Planning Application Ref: WA/94/19/NMA

Location: Land at Tye Lane, Walberton, West Sussex

Description of works: Non-material amendment following the grant of reference WA/95/18/RES for the amendment to approved landscape plans (Condition No 1)

Project	Land East of Tye Lane, Walberton		
Title	Golf Course Netting Indicative Detail		
Client	Linden Homes		
Scale	1:100 @ A3	Drawn	AL
Date	Sept 2019	Checked	GC
Drawing No.	CSA/3823/119	Rev	B

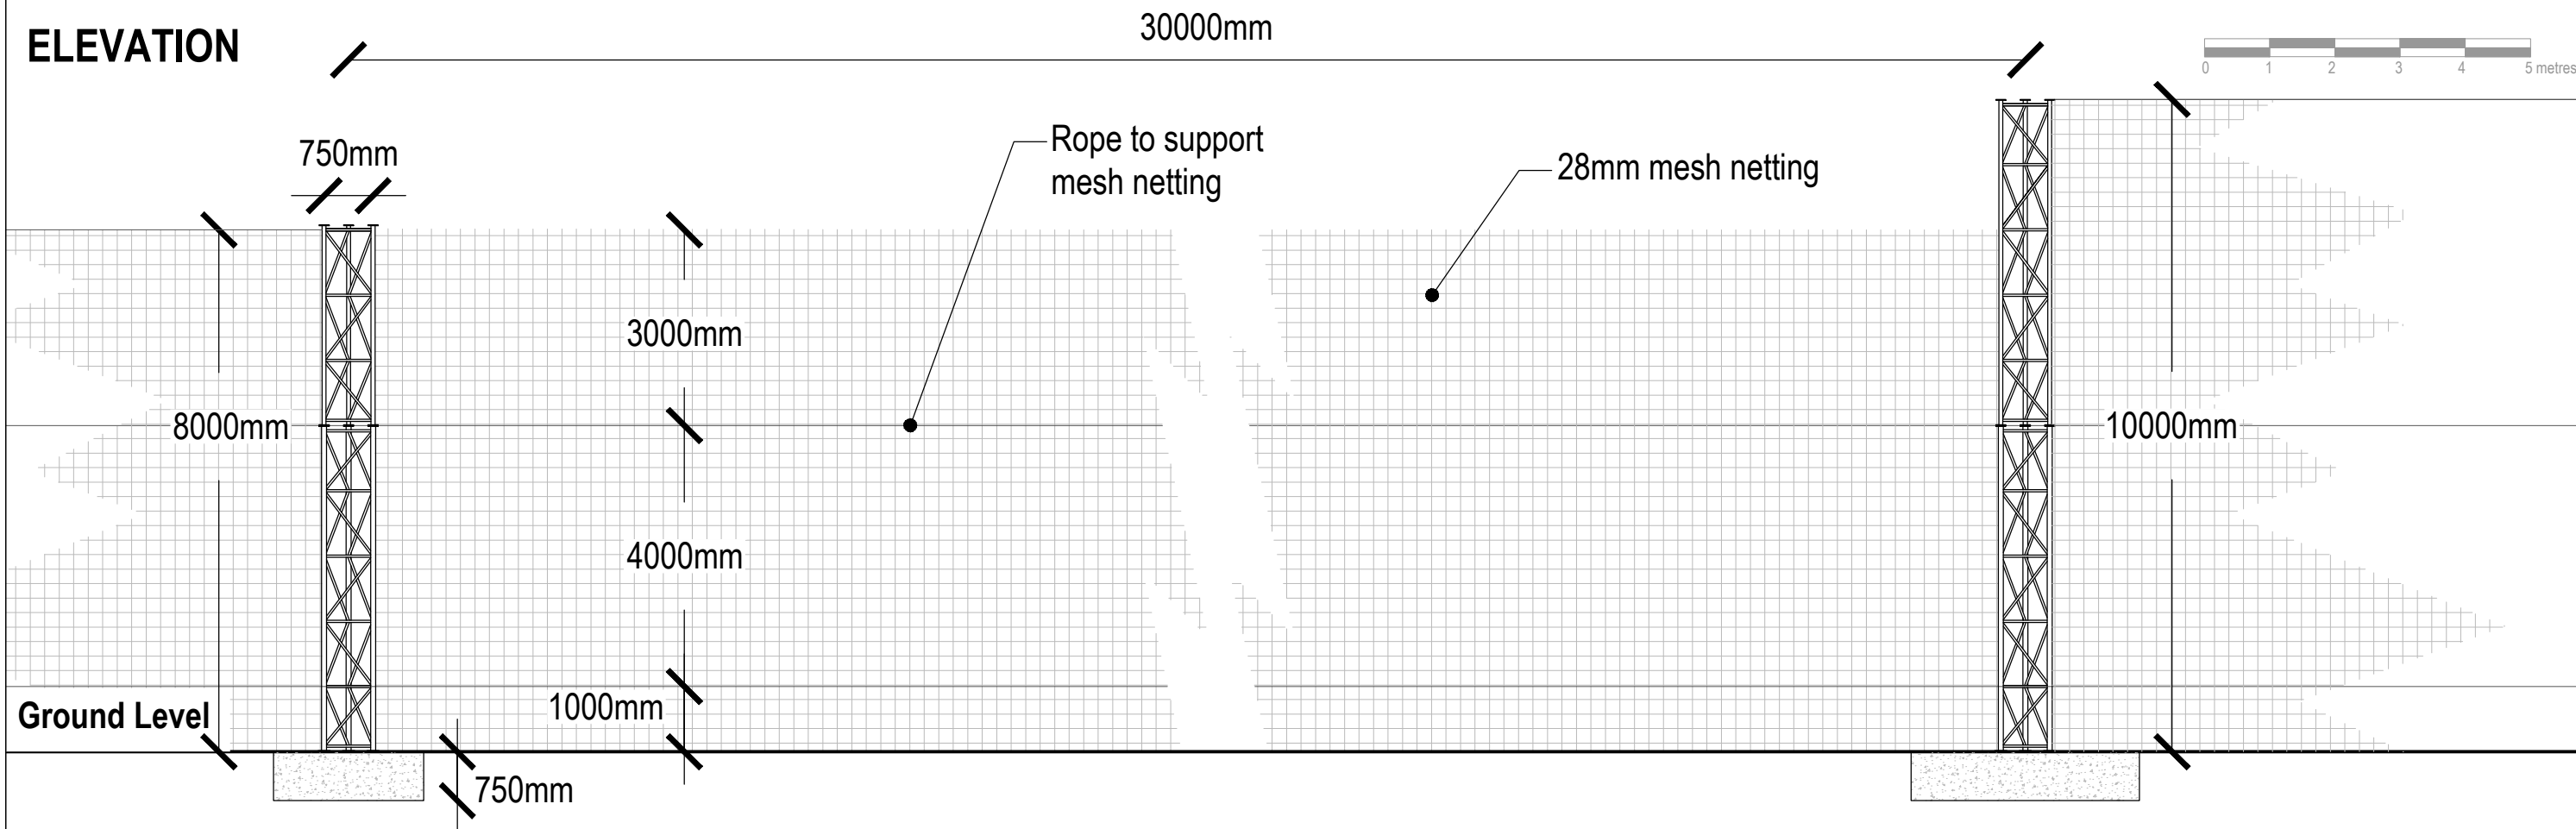
- The four substitute landscape plans show the introduction of a variety of fence and railings both along the site perimeter northern and southern boundary as well as at several locations across the site interior. This will involve construction work within the defined root protection areas of retained trees, some of which are also the subject of statutory protection (Tree Preservation Order).

- While the above reports are comprehensive in all other aspects, there is no stated methodology for how those fences and railings are to be installed and what measures might need to be put in place to ensure no harm occurs to the ongoing health and vitality of retained trees.

-
- The applicant has subsequently instructed their arboricultural consultant (Barton Hyett) to provide an updated version of the above report (ref. C.2636, Rev C) that instructs and details an appropriate methodology for the fence/railing element of the landscape proposals. It also includes that work-stage in an auditable trail of site supervision and monitoring, to be provided in the form of brief report(s) and photographic evidence where necessary. This has been included in the **AIA & MS**, p10, sect.6.9, **Sequence of Site Operations and Compliance Action Requirements**.
